**Consultation Response from KC,  
Highways Development Management**

**2024/92031 Headlands Works, Headlands Road, Liversedge, WF15 7NT**

**Outline application for erection of residential development, adoptable road and public open space**

**Date Responded: 17-9-2024.**

Title: **Existing & Proposed Long Sections**

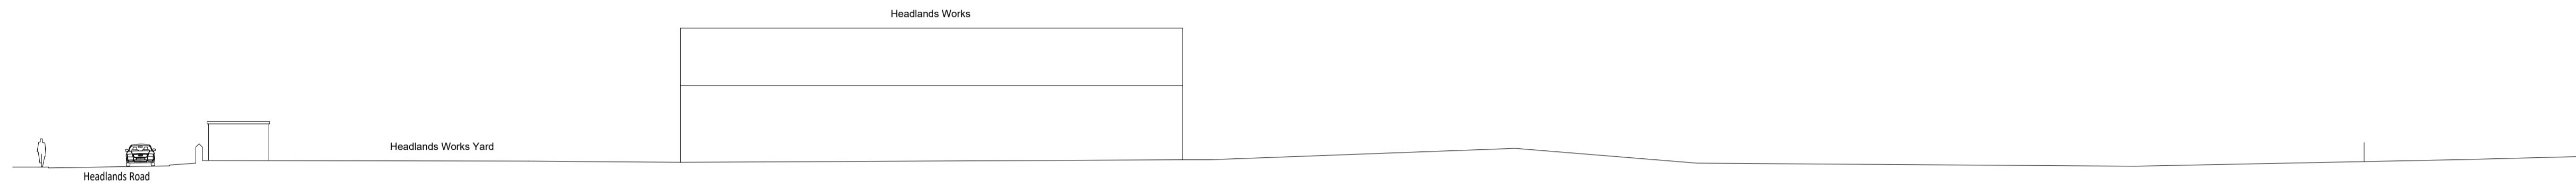
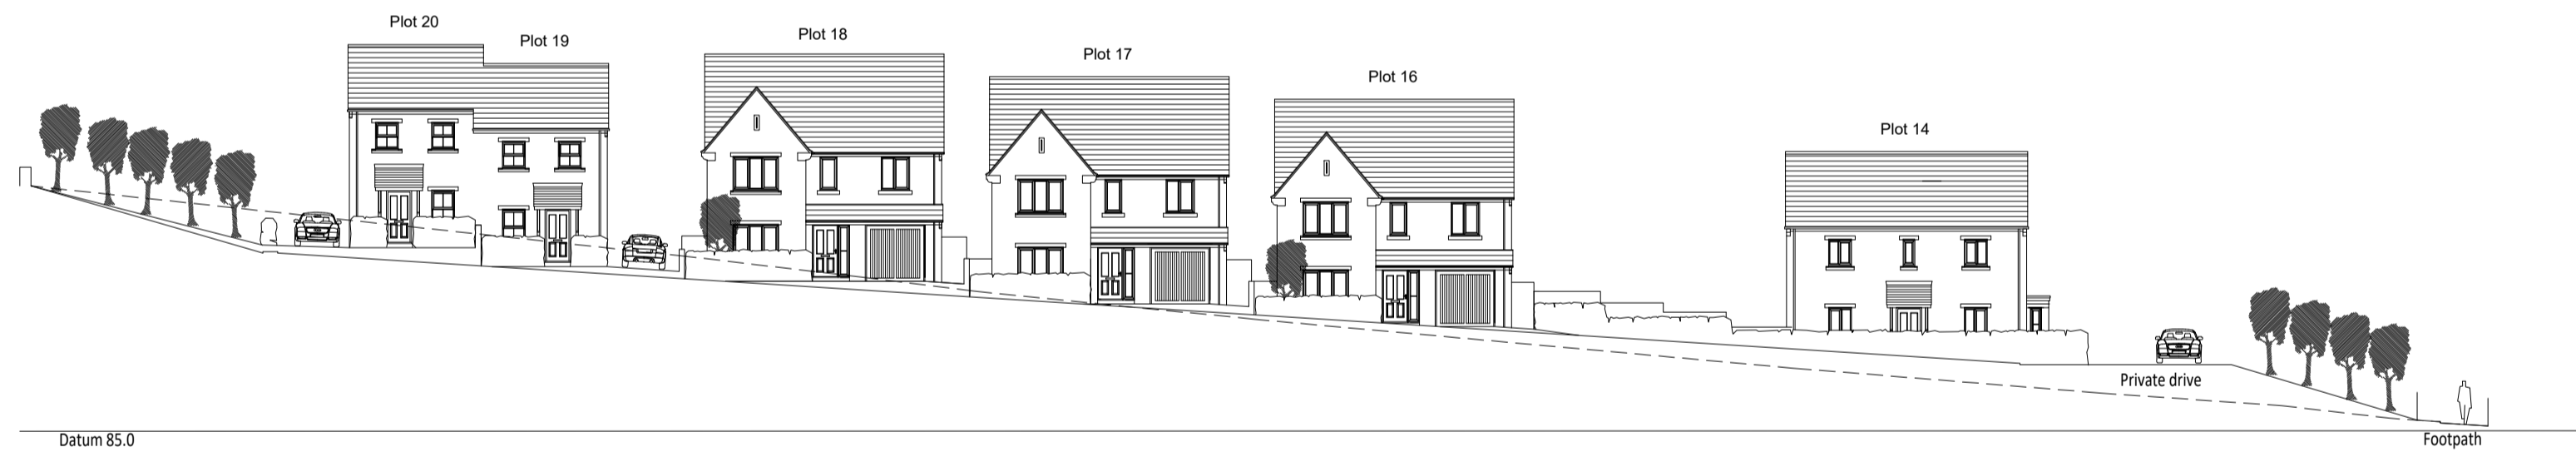
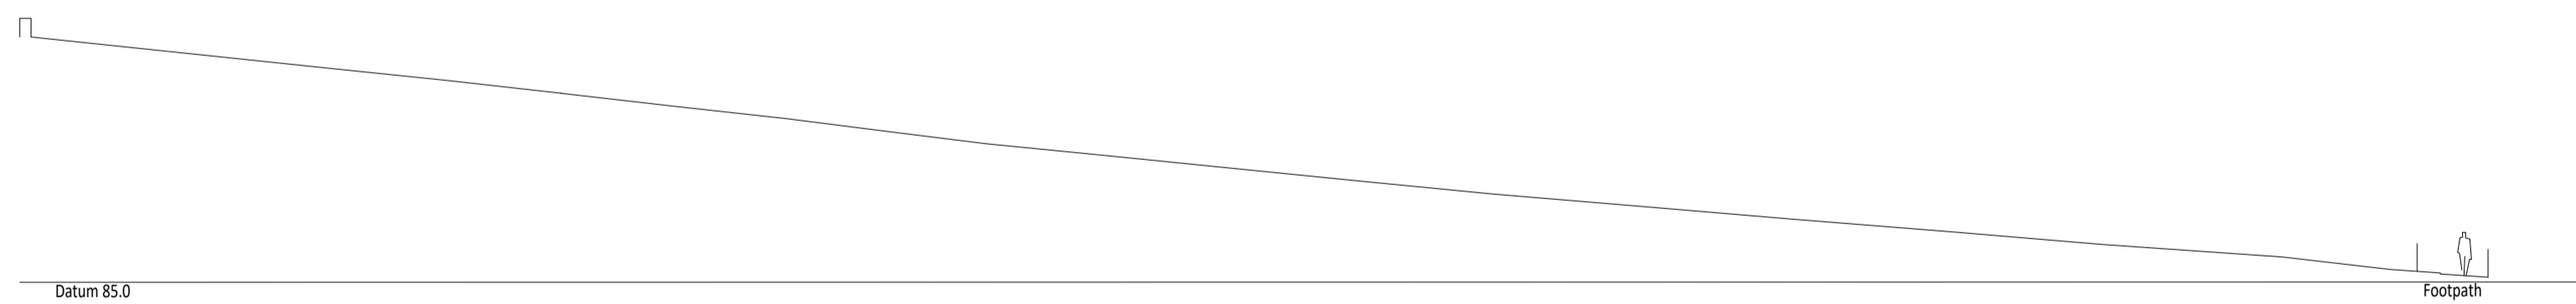
7, Road gradients need to be confirmed.

The desirable maximum carriageway longitudinal section gradient on all adoptable shared surface carriageways is 1 in 20 (5%). If this is not achievable then the specific circumstances should be discussed with the Council to address potential mobility and safety implications. A gradient no steeper than 1 in 10 (10%) is preferred.

The gradient of a non-priority route on the approach to a junction should be a gradient of 1 in 40 (2.5%) for the initial 10 metre length with an absolute maximum of 1 in 25 (4%).
